Our Ref: STH09/01940/30

Your Ref: SSD-12469087

STATE SIGNIFICANT DEVELOPMENT APPLICATION 12469087 – THE GUNLAKE QUARRY CONTINUATION PROJECT - ADDITIONAL SUBMISSIONS

**FIGURE 5 – Lines of sight for light vehicle drivers exiting Red Hills Road**

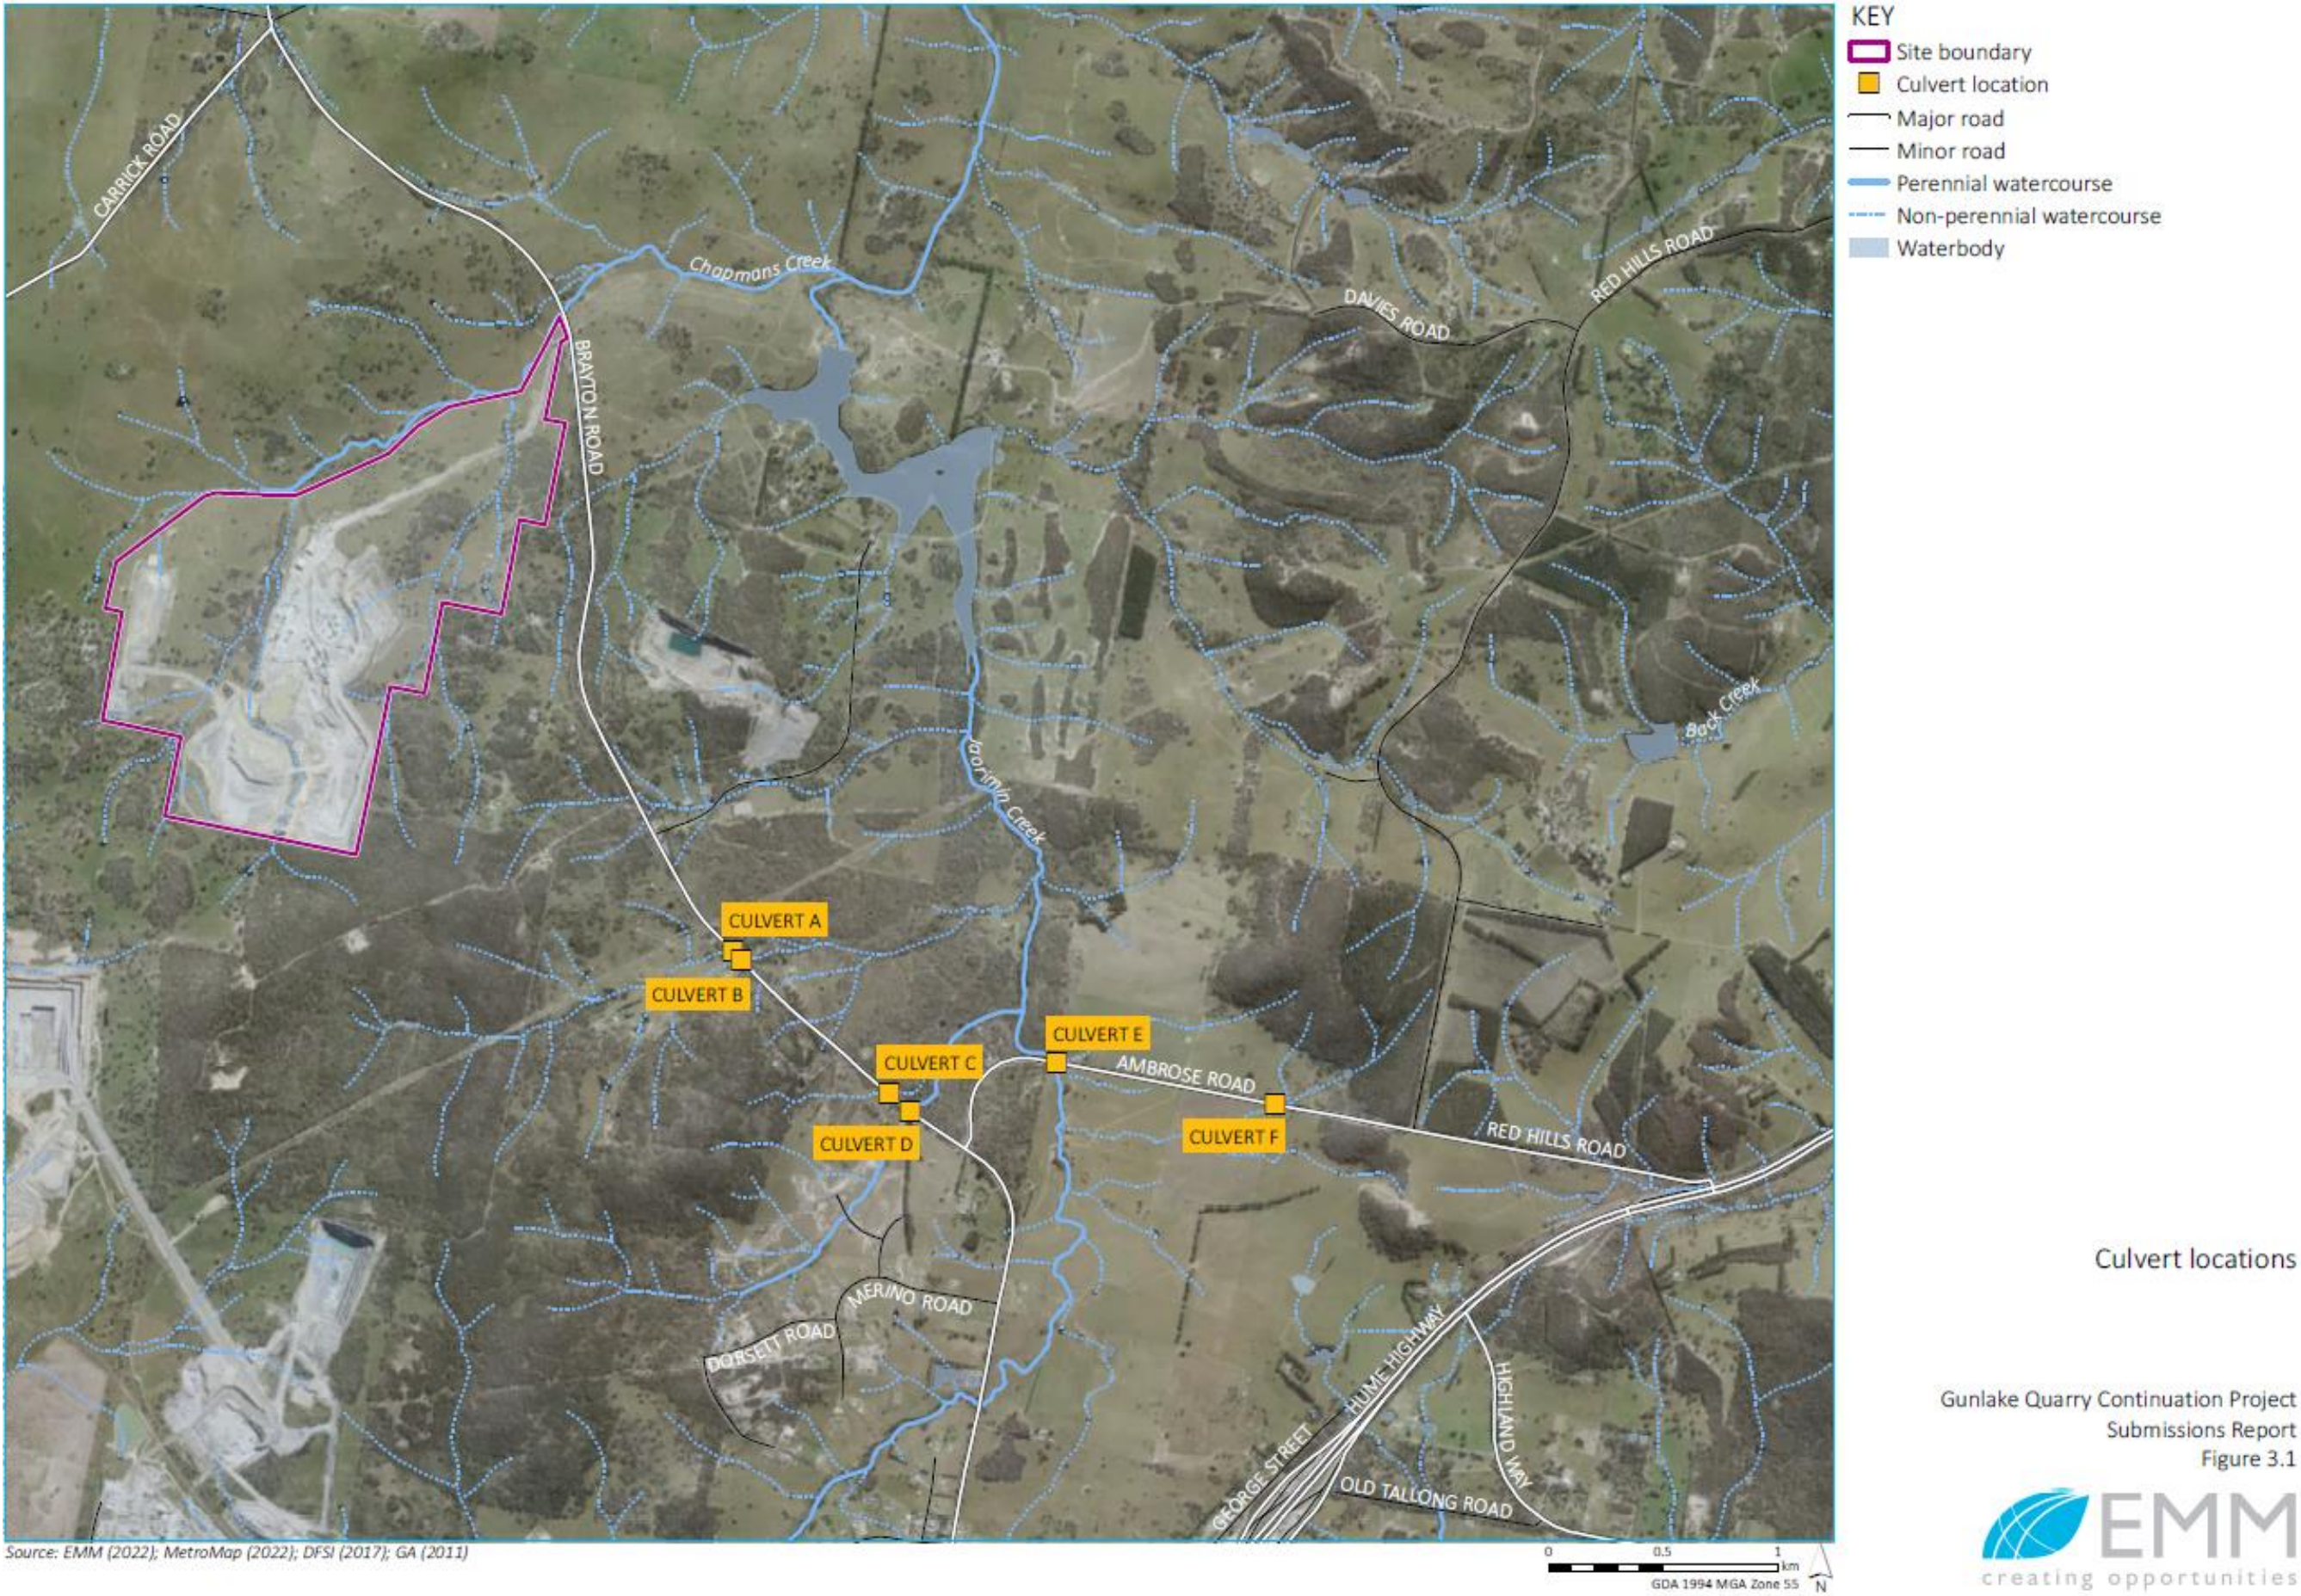
TfNSW notes that all access to the site for heavy vehicles will be gained via the intersection of Red Hills Road and the Hume Highway. TfNSW also notes that the current SSD application will significantly increase heavy vehicles using this intersection to access the development site (i.e. a 21% increase over what is currently approved).

In its letters dated 3 December 2021 and 31 May 2022, TfNSW sought additional details from the applicant/quarry operator on measures that will be implemented to stop/prevent vehicles departing the Hume Highway via Red Hills Road cutting the corner (southern side of the Red Hills Road/Hume Highway intersection) and damaging the edge of road pavement and infrastructure within the road reserve (e.g. existing pits, guide posts, etc). The cutting of this corner is evident when viewing Google maps/images (refer to **Attachment 3**) and from visiting the site.

TfNSW believes that the above will require a concept design for what is being proposed to be submitted to the Council for review and approval (inclusive of swept paths) before the determination of the current SSD application. It is also important to note that should works be undertaken within three (3) meters of the travel lane of a state classified road (i.e. Hume Highway) or work that has the potential to impact traffic flow such as the use of traffic control devices or signage to protect workers, then a Road Occupancy Licence (ROL) from
